Submission No.			090	
Organisation Name or Name of Submitter			Estuary Court Residents Association (16 Estuary Court, Swords), Submission No 1 (prepared by Barry Arthurs)	
Letter Re: Railway (MetroLink-Estuary to Charlemont via Dublin Airport) Order 2022, Estuary Court Submission No. 1- Re-alignment of MetroLink route out of family housing estates onto the R132

Submission No.	090
Organisation Name or Name of Submitter	Estuary Court Residents Association (16 Estuary Court, Swords), Submission No 1 (prepared by Barry Arthurs)

Letter Re: Railway (MetroLink-Estuary to Charlemont via Dublin Airport) Order 2022, Estuary Court Submission No. 1- Re-alignment of MetroLink route out of family housing estates onto the R132

Drawing Title	METROLINK - GENERAL ARRANGEMENT SEATOWN (SHEET 1 OF 3)		Drawing Status	S1
Drawing N°	ML1-JAI-ARD-ROUT_XX-DR-Y-03012	Plan Drawing N°	ML-RO 301 H-J	
Scales Original Size A1	AS SHOWN	Sheet	1	of 1

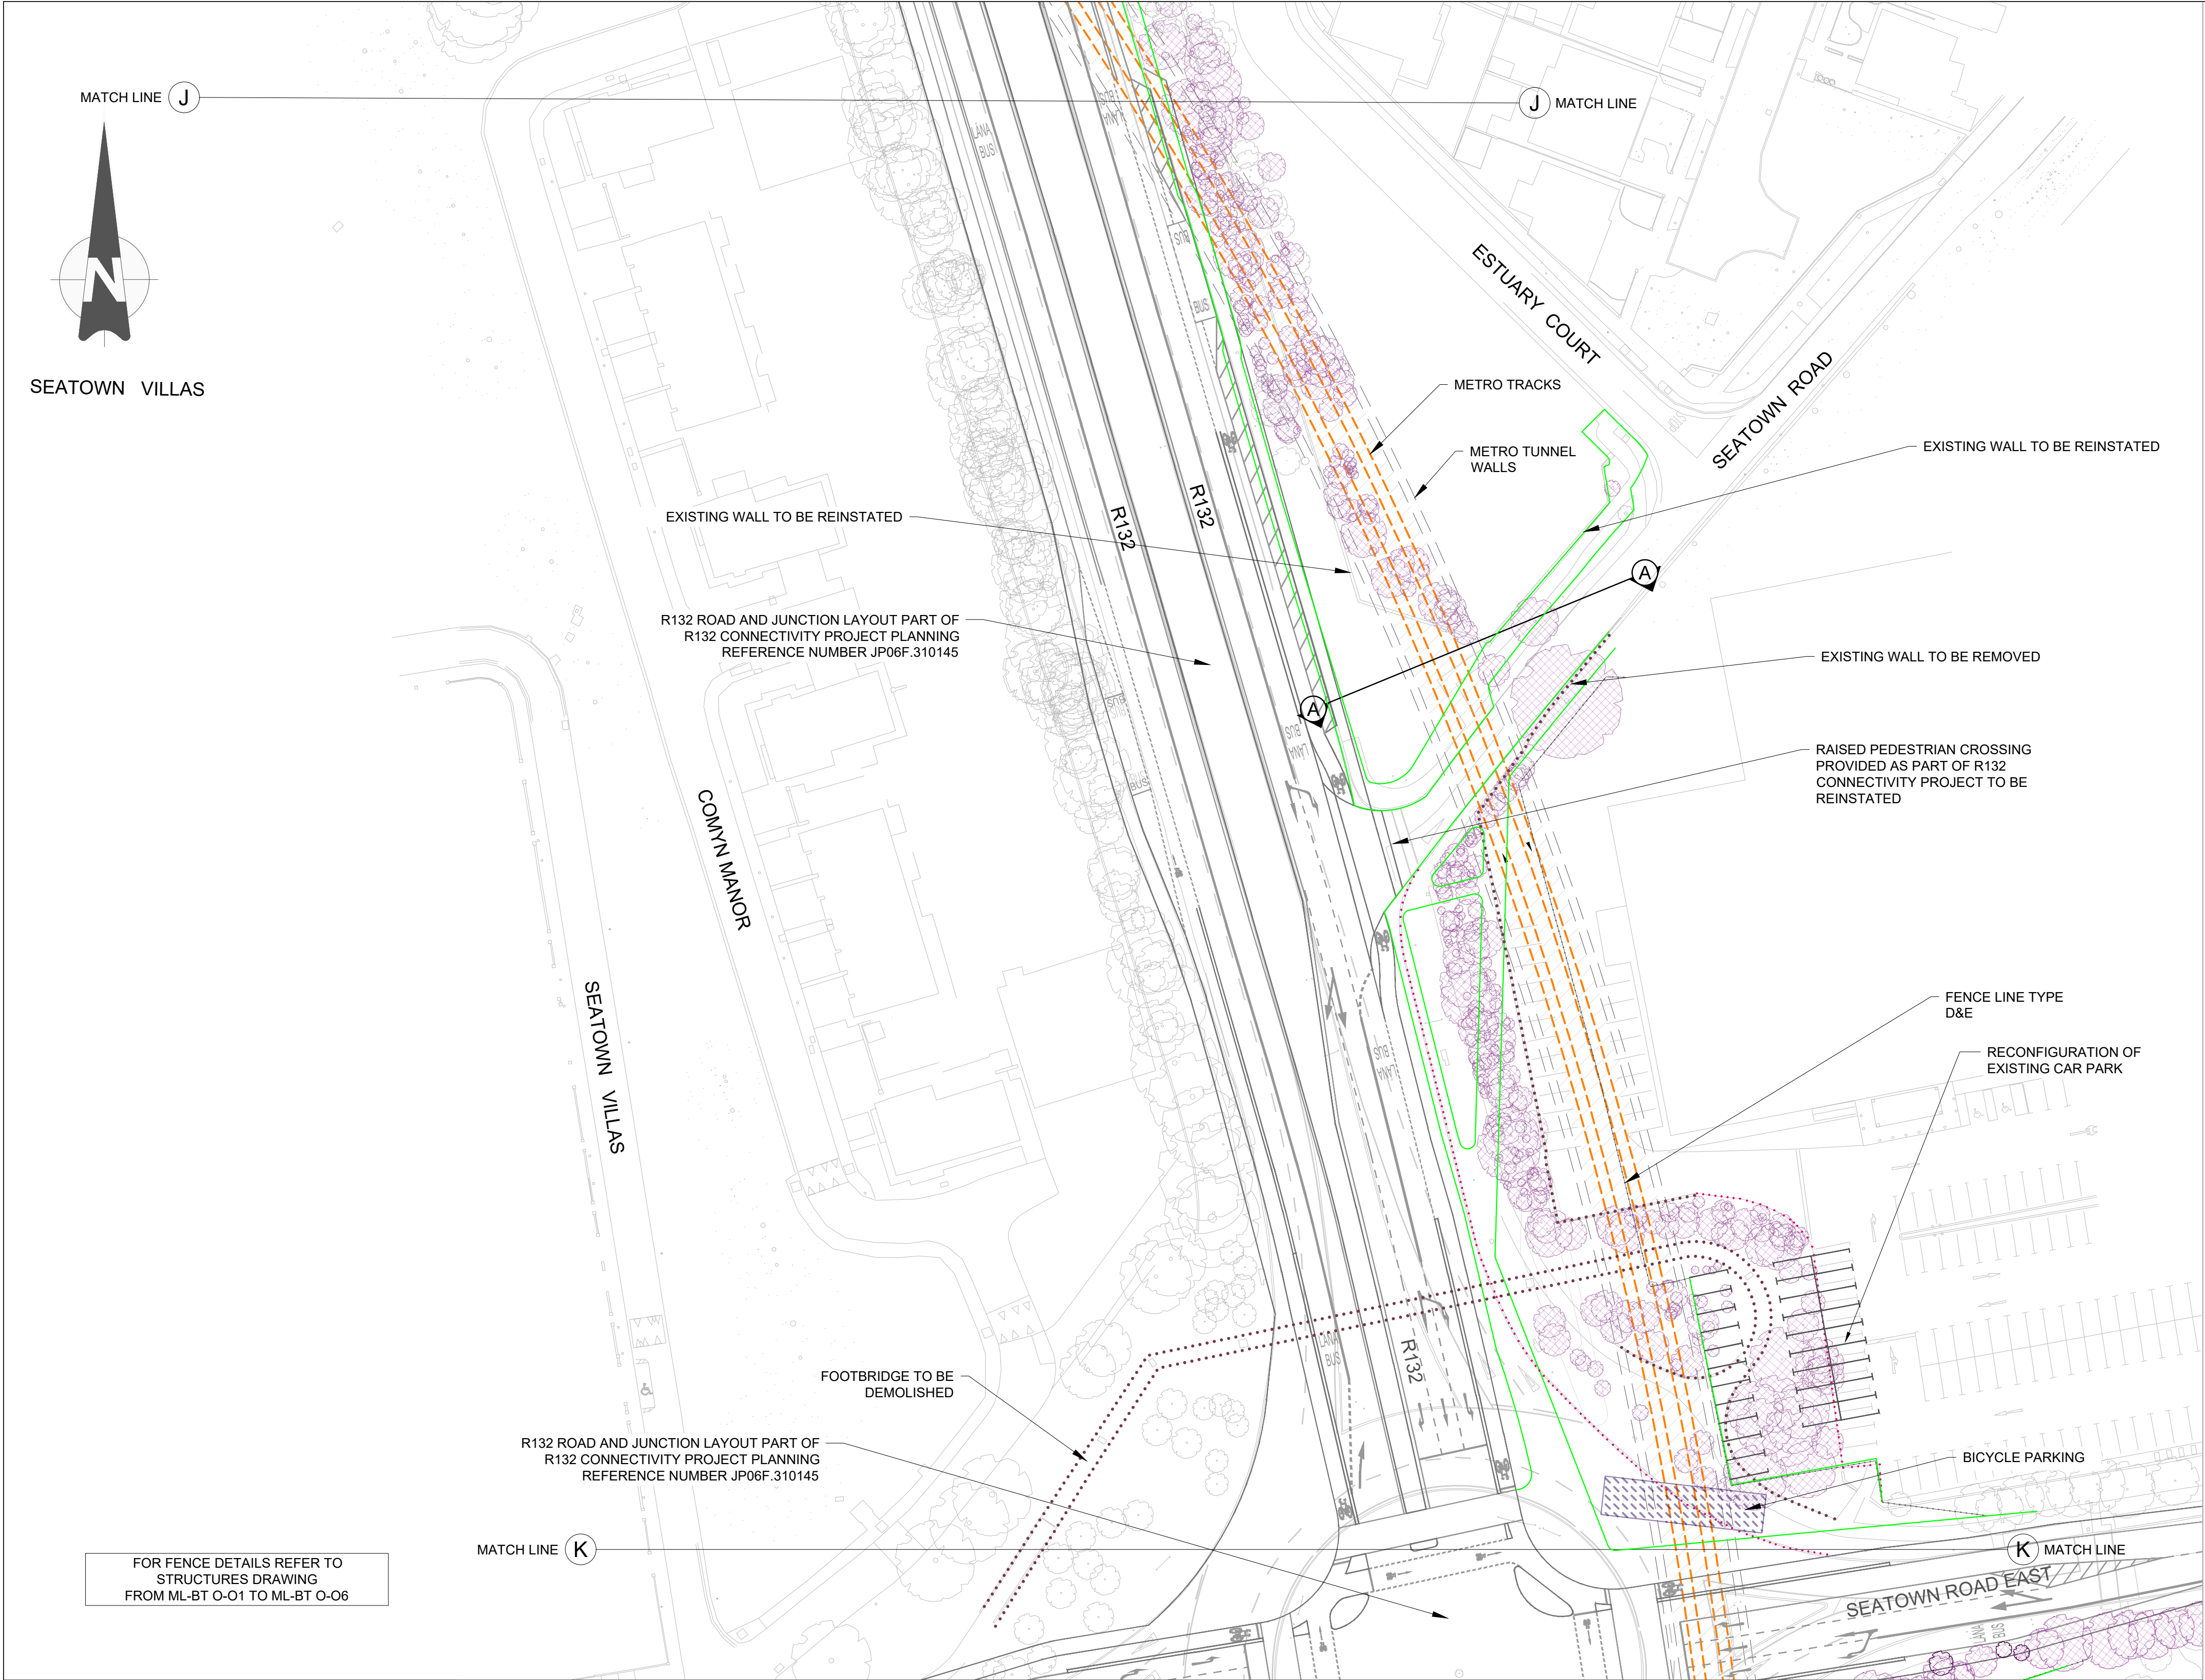
6	1. Introduction	12	With the TII's proposed plans, our housing estate will no longer be child friendly, and this will ultimately ruin the little community that has been established here over the last 30 years. This has already caused great stress and anxiety to many of the residents in Estuary Court. While the residents of Estuary Court do not oppose the MetroLink project, we strongly believe that the MetroLink route does not need to come through our estate. We have engaged with the TII over the last 2 years and to date they have not been able to provide a definitive answer as to why the MetroLink needs to come into our estate instead of following the R132 road.	See response numbers (3), (4) above and (7) below.
7	2. Impact of MetroLink Route Cutting Through Estuary Court	13	The current proposed MetroLink route cuts through the top green of Estuary Court. However, the TII plan to take both of our green spaces for the duration of the construction works. The top green for constructing the cut and cover tunnel through it, and the bottom green for a site compound. They also plan to demolish our boundary wall along the R132 and cut down the mature trees and landscaping along it. At a high level the three the main impacts for Estuary Court of the proposed TII preferred alignment are as follows: <ul style="list-style-type: none"> • Loss of open green space • Loss of mature trees, landscaping and boundary wall • Disruption from construction works 	<p>See also response numbers (3) and (5) above.</p> <p>Details of the requirements and provision of Construction Compounds are given within section 5.3 of the EIAR Chapter 5: MetroLink Construction Phase. Volume 4 Figures, Chapter 5, MetroLink Construction Figure 5.1 Construction Compounds provides details of all the proposed sites along the alignment, noting that the vast majority, with two exceptions, are positioned in "commercial/industrial" designated land.</p> <p>The Satellite compound designated at Estuary Court, opposite the residents will be required for 36 months to undertake the main MetroLink works within the boundary of the site at this location, including: - The cut & cover and retained cut structures. - The reinstatement of the permitted landscape on the completion of the alignment structures. Note that locations of construction compounds proximate to the workforce site are essential to achieving the projected programme for the works.</p>

Item No.	Section Ref.	Page No.	Observation Statement	TII Response
8	2.1 Loss of Open Green Space	14 and 15	<p>The loss of open green space will have a devastating effect on the young children in the Estate. With very small back gardens, the young children will have no green space to play ball games or even run around. The only place the children will have to play is on the road, raising safety concerns. The original timeframe provided to us by the TII for using the greens was:</p> <ul style="list-style-type: none"> • 2 years for the top green; • 6-12 months for the lower green. <p>When considered with the actual cut and cover and open cut construction, the estimated duration through this area is between 51 and 69 months. Given that construction programmes often over-run for projects of this size, we envisage the length of time could easily extend to be a lot longer.</p> <p>This also doesn't allow for the time it would take for the new grass to get established and be suitable for playing on. This would take another year. It is very probable that our top green would be unavailable to the kids for 5/6 years and the bottom green 4/5 years. This might not seem like a long time to an adult but for the young kids under 10 in our estate, this could be half of their lives and a pivotal time for their growth and development. This will have a significant impact on their young lives.</p>	<p>See response number (7) above.</p> <p>Chapter 11 Population and Land Use Section 11.6.1 also notes the following:</p> <p>Community Relations Officers (CRO's) will be employed during the construction of the proposed Project and contact details will be provided on the proposed Project website so that stakeholders and communities can make contact as required. The CRO's will be responsible for maintaining open, transparent and positive relationship with members of the public, local businesses, groups and organisations affected by the works. Specifically, the CRO's will work closely with Transport Infrastructure Ireland and the appointed contractors to ensure that all effort to address public concerns are made, and to ensure that information on the nature and duration of all works is provided; and ♣ Reinstate all land as quickly as possible following construction so as to expedite any local disruption and return to existing surface land uses that can be used by the surrounding residents, businesses and communities.</p>

11	2.2 Loss of Mature Trees and Landscaping and Boundary Wall	16	<p>The TII originally proposed not to reinstate our boundary wall. They wanted to take over our green spaces as part of a linear park. We have engaged with them on this over the last two years and the proposed plan in the Rail Order now includes for wall type H (not defined). However, they have included access gaps in the wall which makes it ineffective for security and the safety of our children playing on the green. Please see our Submission No. 2 - Submission 089 for further detail on this.</p>	<p>See response number (3) above</p>

23	5. Opportunity from R132 Connectivity Project	26	The R132 is approximately 42m wide from boundary wall to boundary wall. Based on standard road lane widths, this could easily accommodate a new urban street type road on one side (approx. 2/3 of the road) and the construction of the Metrolink on the other side (approx. 1/3 of the road). The Metrolink is planned to be cut and cover for most of the R132 so by keeping to this method on the R132, this would provide an ideal route above for cycle lanes / pathways / landscaping all along the R132. We believe that the R132 Connectivity Project should be considered in full as part of the decision making for the best option. There are opportunities for both projects to work together and achieve a better and sustainable solution that does not need to disrupt and destroy the safe family environments in the three different housing estates along the route. None of the construction works have started on either project so it's not too late for the relevant design teams to come together and redesign the section of R132 that will provide the optimum solution for both the Metrolink and the Connectivity Project.	As stated above in response number (4) TII have reviewed many options for the delivery of the MetroLink through Swords with the option presented in the EIAR the least impactful to the stakeholders along the R132, while resolving the visual impact objection to the elevated alignment and ensuring that the scheme remains economical for delivery under the business case. Alternative Residents Solution. As with all of the options considered, the solution proposed on Fig 5.1 to effectively build the MetroLink Alignment under the existing R132 Southbound c/way is of course possible. However, we would offer the following initial observations in addition to those previous stated in response number (4) above: <ul style="list-style-type: none"> This alternative scheme assumes a full cut & cover solution, which is not the scheme proposed under the EIAR, nor was it ever TII's intention to provide such a scheme when moving away from the initial preference for an elevated alignment. See response number (13) above. In its current layout, this alternative scheme would be unworkable in delivering the R132 Connectivity Scheme with an open retained MetroLink alignment. However, it is potentially feasible to have an open retained MetroLink with a full R132 Connectivity configuration running alongside it but pushed into the northbound verge. Further impacts of such a solution are outlined below.
